**DEVELOPMENT HEARING OFFICER  
Action Summary**

**May 10, 2023**

- 
1. [PR-2021-005628](#)  
SD-2023-00094 – VACATION OF PUBLIC EASEMENT  
SD-2023-00095 – VACATION OF PRIVATE EASEMENT  
SD-2023-00096 – AMENDMENT TO FINAL PLAT  
*IDO – 2021*

- 
2. [PR-2021-005597](#)  
SD-2023-00092 – FINAL PLAT  
*IDO - 2021*

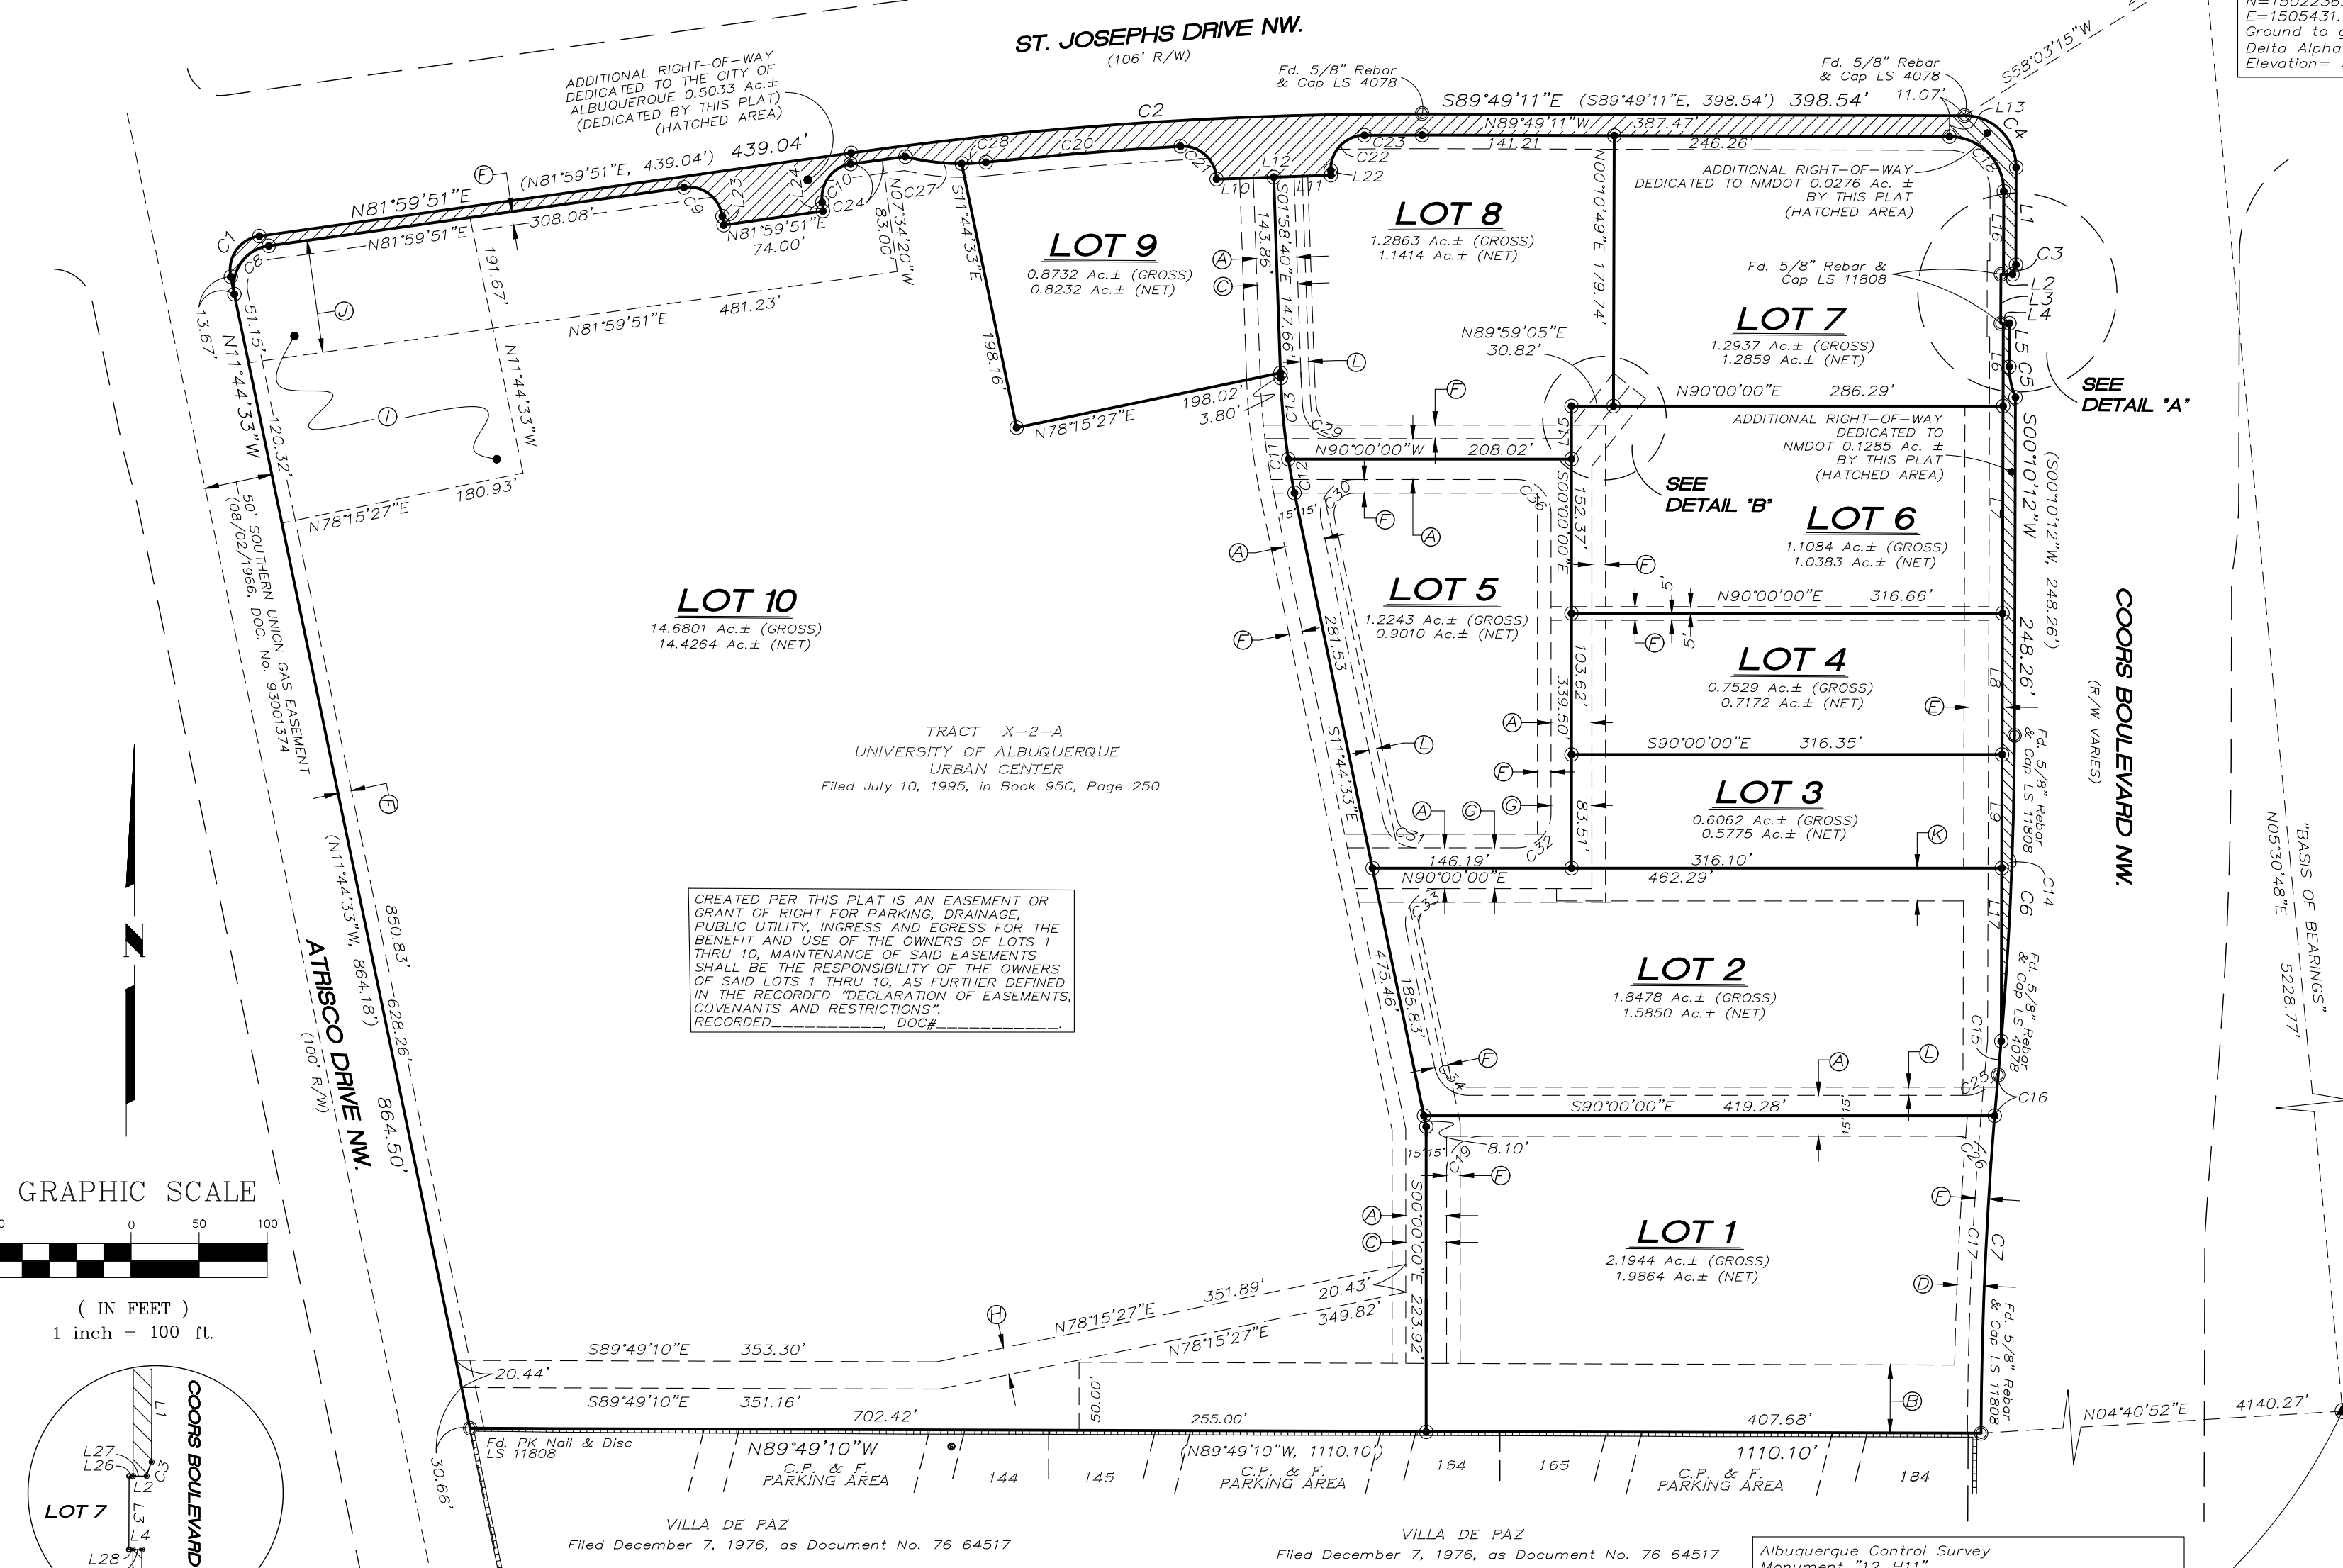
- **PAYMENT OF PRO-RATA**
- **ADDITION OF THE STANDARD EASEMENT NOTE PRIOR TO FINAL SIGN OFF**

**TRACTS A THRU M
CITY CENTER**
BEING A REPLAT OF TRACT 17 OF ARTISTE
(BULK LAND PLAT, TRACTS 1 THROUGH 18, ARTISTE)
CITY OF ALBUQUERQUE
BERNALILLO COUNTY, NEW MEXICO
FEBRUARY, 2022

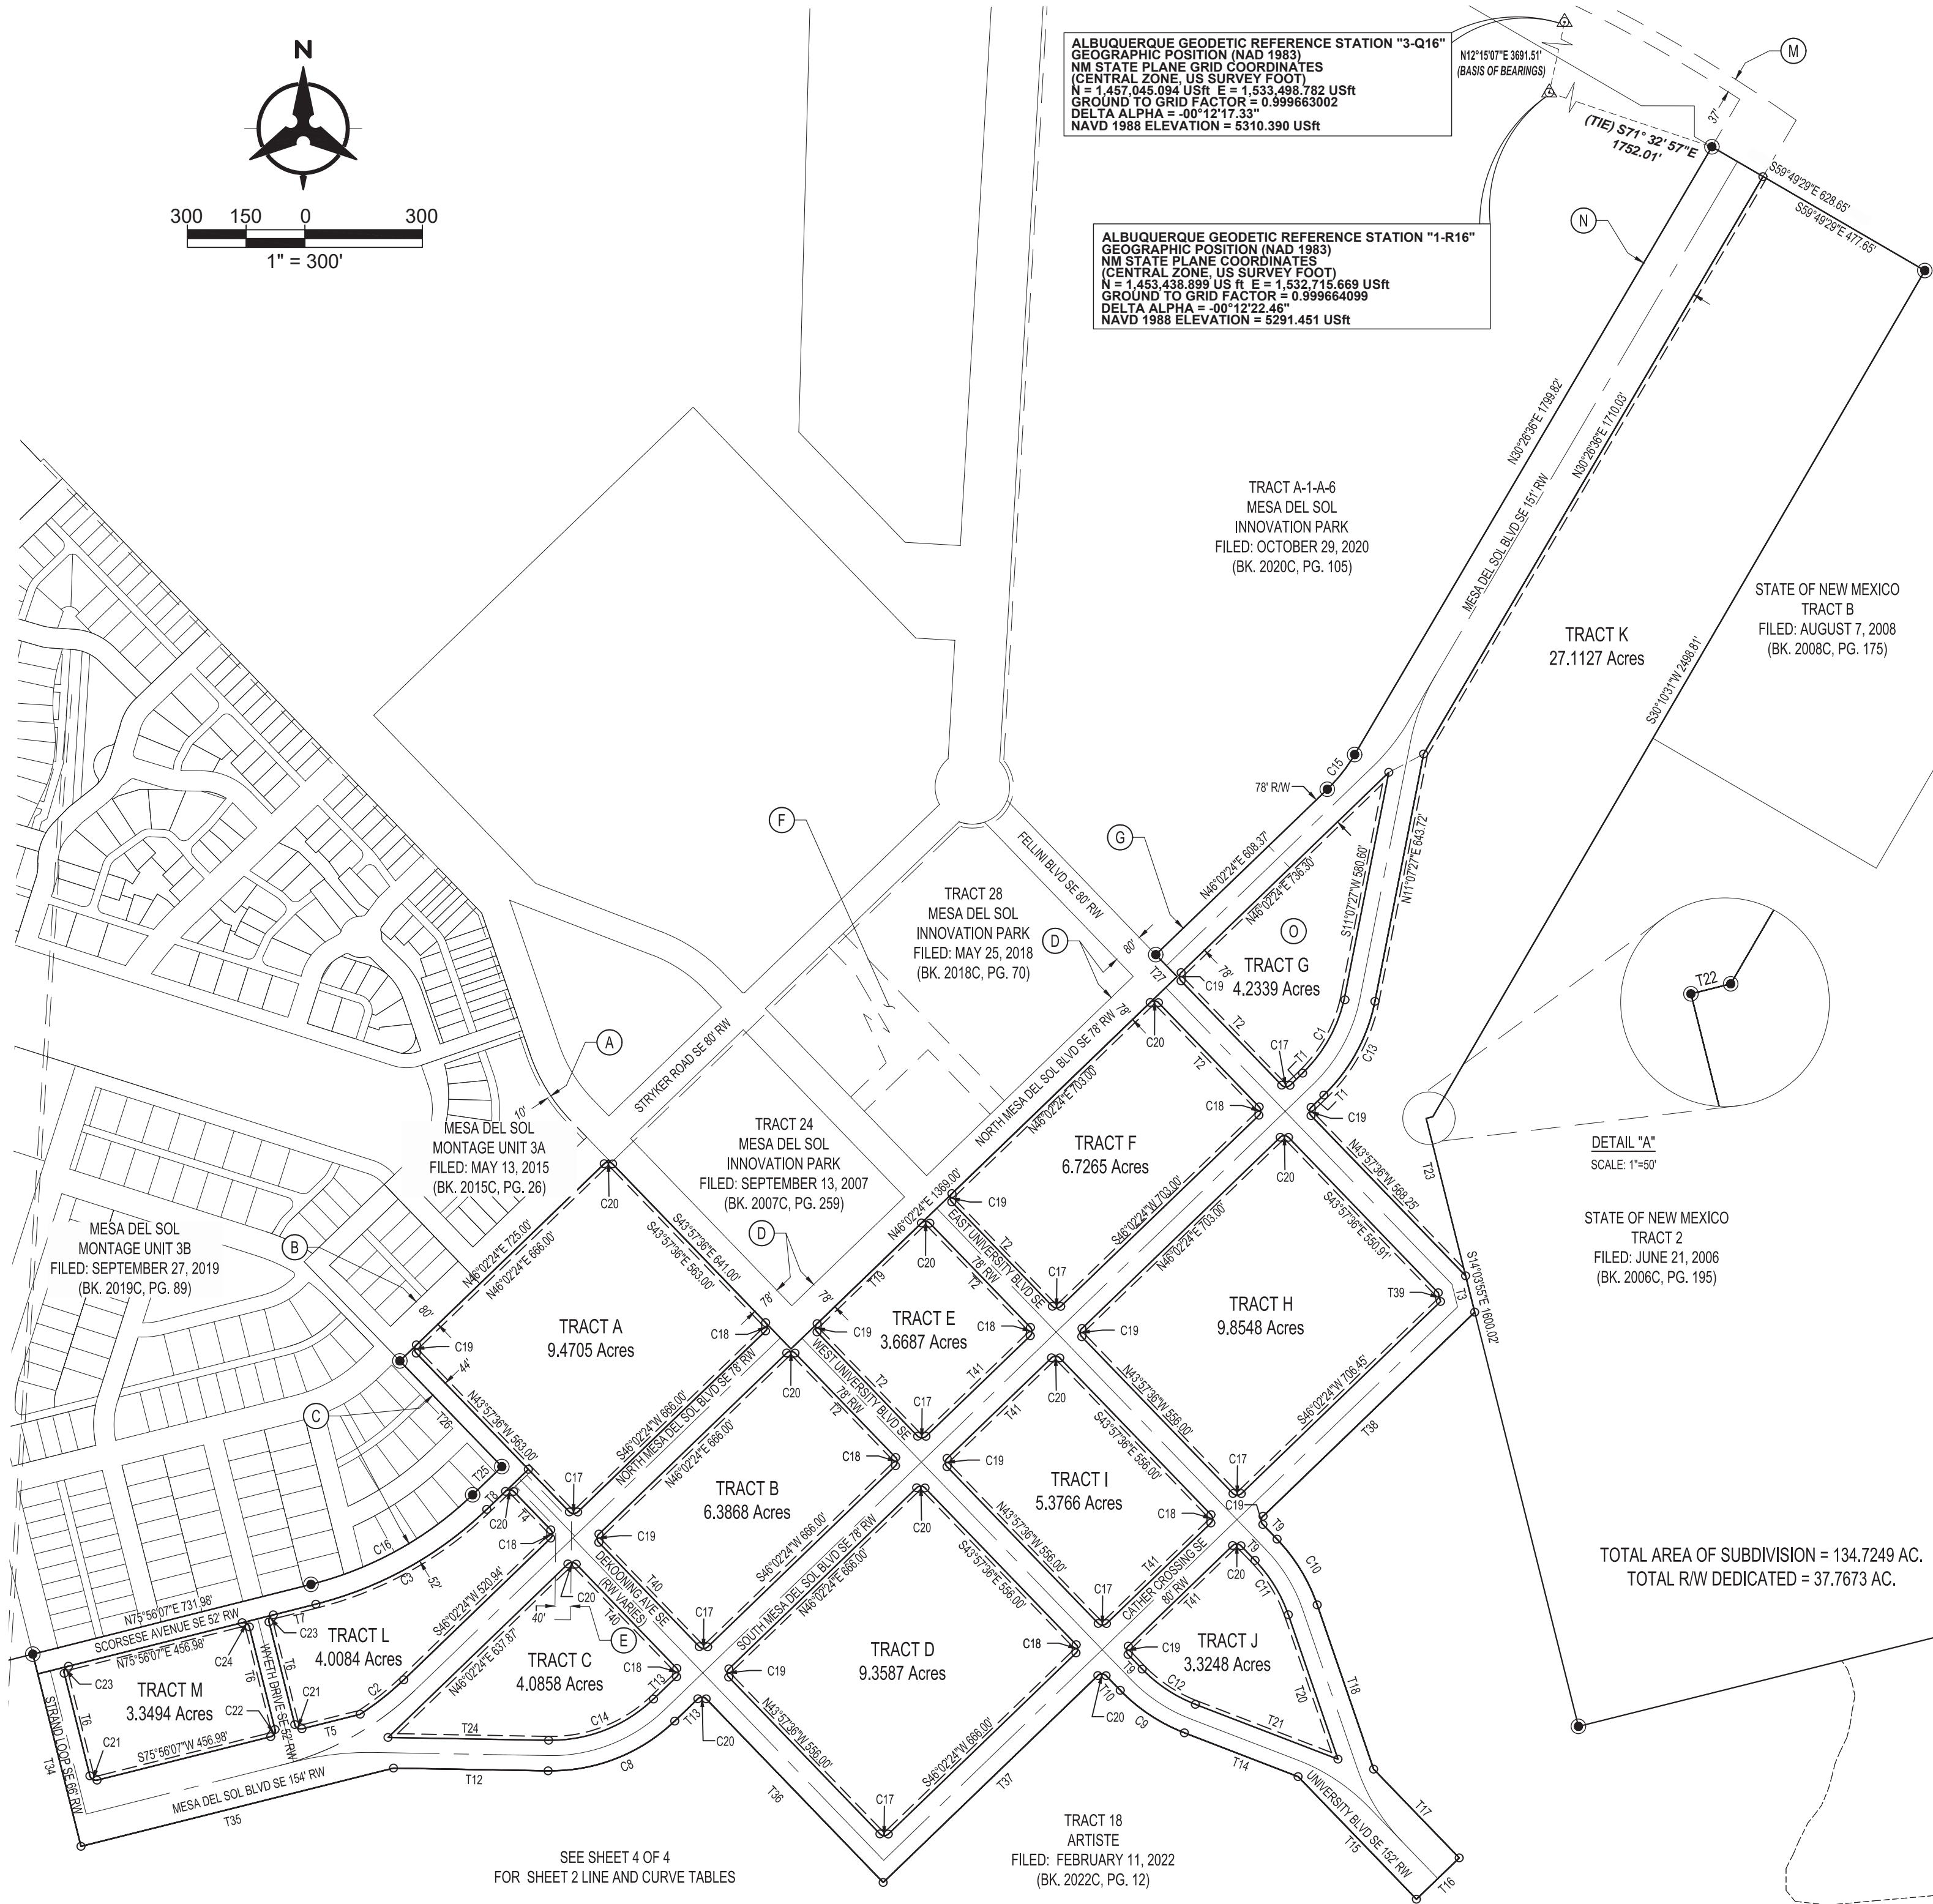
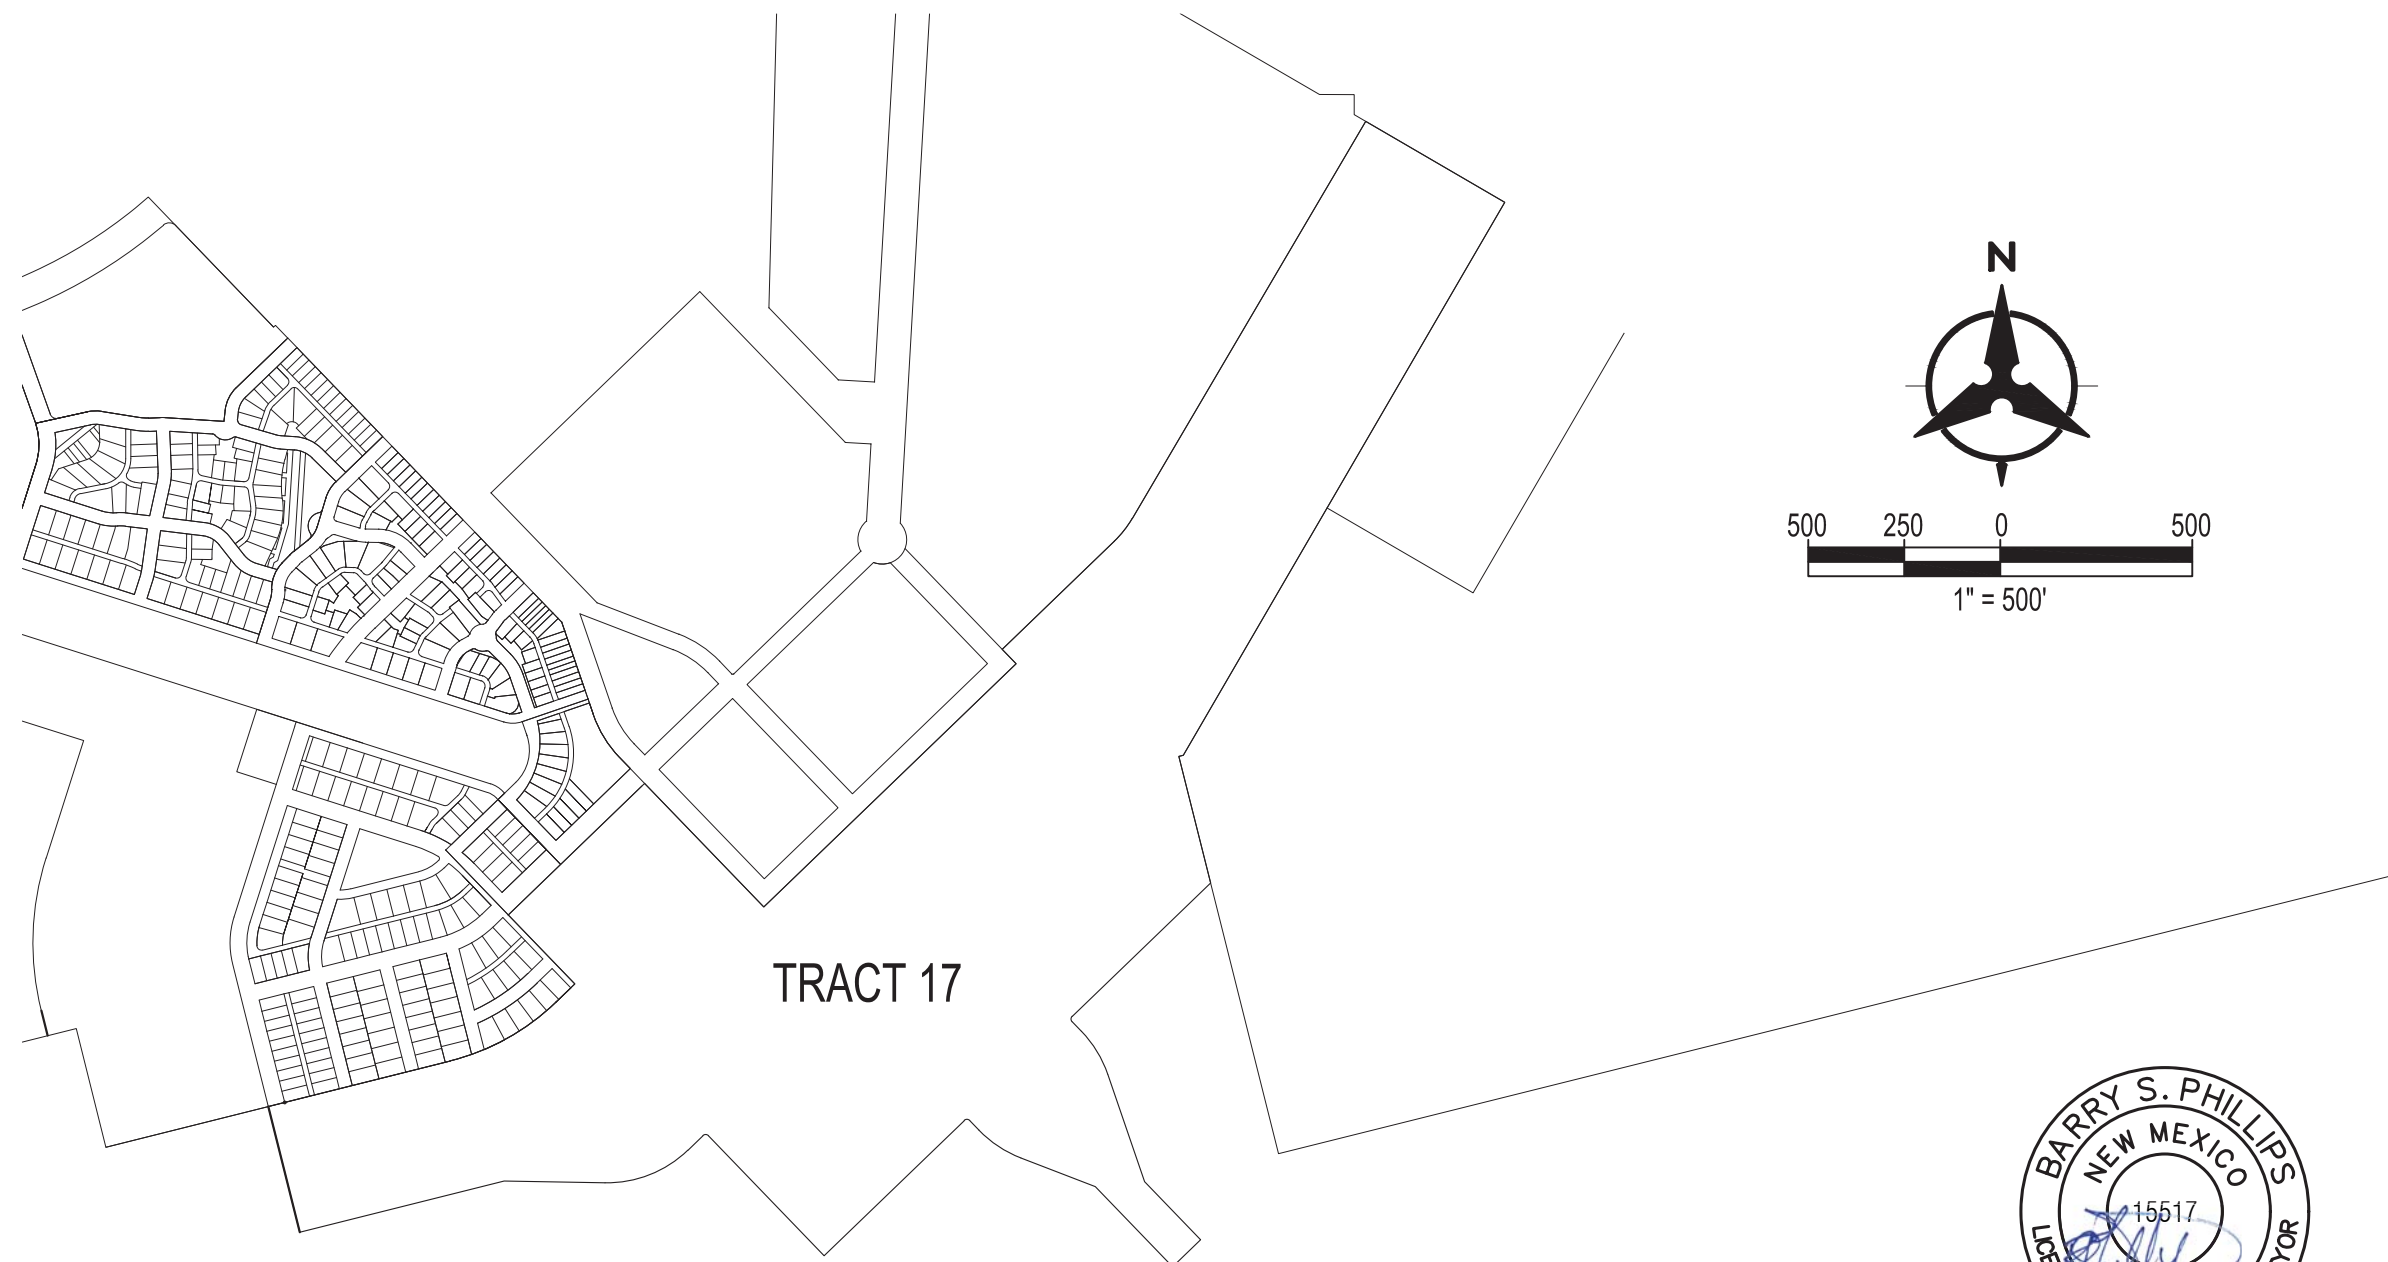
- **THE APPLICATION NUMBER MUST BE ADDED TO THE PLAT**
- **ADD REMAINING VACATION INFORMATION ONTO THE PLAT**
